I would like to register my objections to the proposed rear and side extension to 17 Grosvenor Road, Batley which lies within the Upper Batley conservation area due to the following reasons.

Revisions	Date	Aug 2023	Planning Application for:
			Proposed Rear & Side Extensions
			17 Grosvenor Road, Batley
			Drawing Title:
			Proposed Plans and Elevations
			Drawing No: S04
			Rev B
			Scale: As shown Paper Size: A0

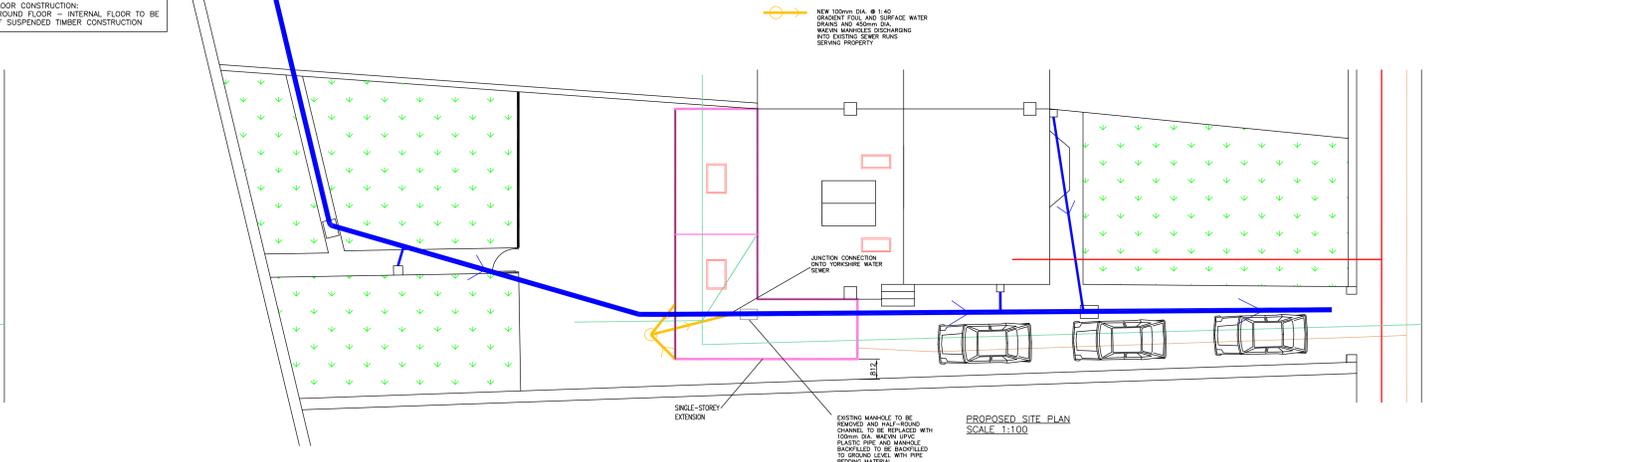
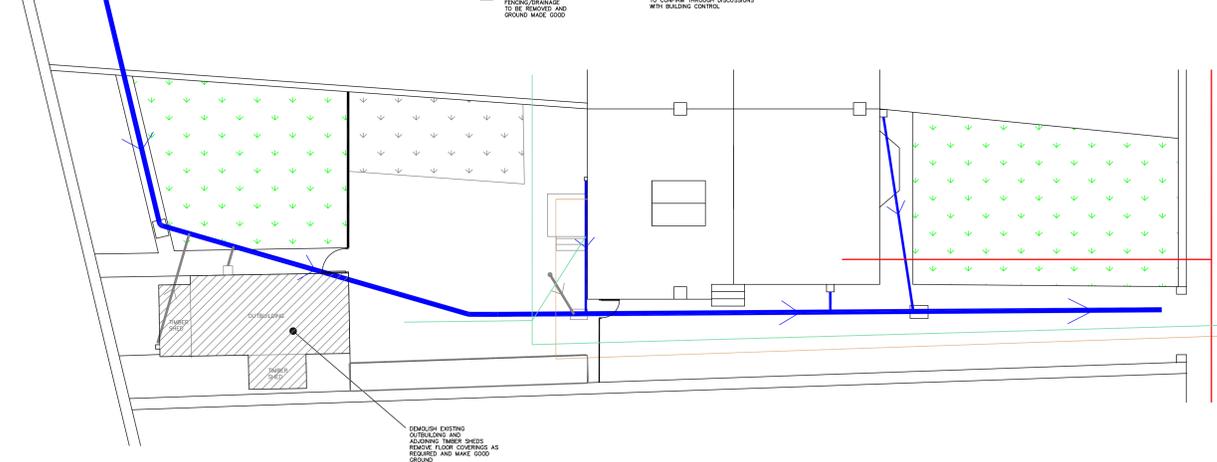
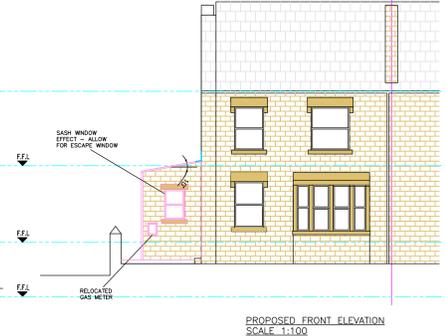
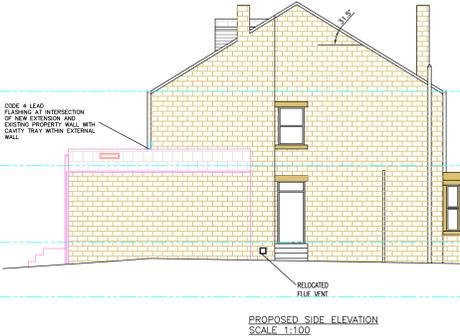
1- The property is within the Upper Batley conservation area which strives to retain the original character of the area. This proposed extension being a wraparound will not meet this requirement. Extensions have been added to properties within the area but they have been to the rear elevation only so as to not block the vista between the properties.

2- The proposed rear extension projects 3.3m from the rear elevation which exceeds the maximum permitted 3.0m also the ridge height is 4.5m, as both dimensions exceed the guidelines of the House Extensions and Alterations SPD being 3.0 and 4.0m respectively. It would not be accepted under a large extension application also due to the increased eaves height of 3.6m and ridge height of 4.5m, it is also a wraparound extension again not meeting guidelines.

3- The proposed rear extension is shown as being built up to the boundary line to no19 taking no account of the existing dividing fence. The properties also have a basement level to the rear which will result in a deep foundation being required which will cause potential collapse of the rear yard to No19 and the retaining wall to the boundary of No15. The new foundation to the boundary of No19 will also project over the boundary line with the toe projection from the wall. Once again, the House Extensions and Alterations SPD states that a minimum of 1.0m should be maintained from the boundary.

4- The proposed extension being built close to the boundary of No19 will also cause a rainwater discharge problem as no external gutter will be fitted as it would project over the boundary line. A convoluted gutter as shown in Detail 1 is proposed but this would not prevent water runoff being discharged directly over the boundary line on to the ground.

5- The final objection is the overshadowing caused to the rear elevation lounge window of No19. With the larger projection from the rear wall of 3.3m and the raised eaves height of 3.6m being so close to the boundary extensively fouls the 45 deg splayed line. This together with the orientation of the properties will cause a substantial loss of light whilst also creating an overbearing feeling to the garden area and lounge room. The 3.6m eaves to the boundary of No15 will also cause an extreme overbearing feeling as the external ground level is stepped down, with No17 being some 750mm higher thus exaggerating the height of the extension to some 4.4m high within 800mm of the boundary line which will affect the 2no windows to side elevation of No15 which at present are shaded by the existing dwelling.
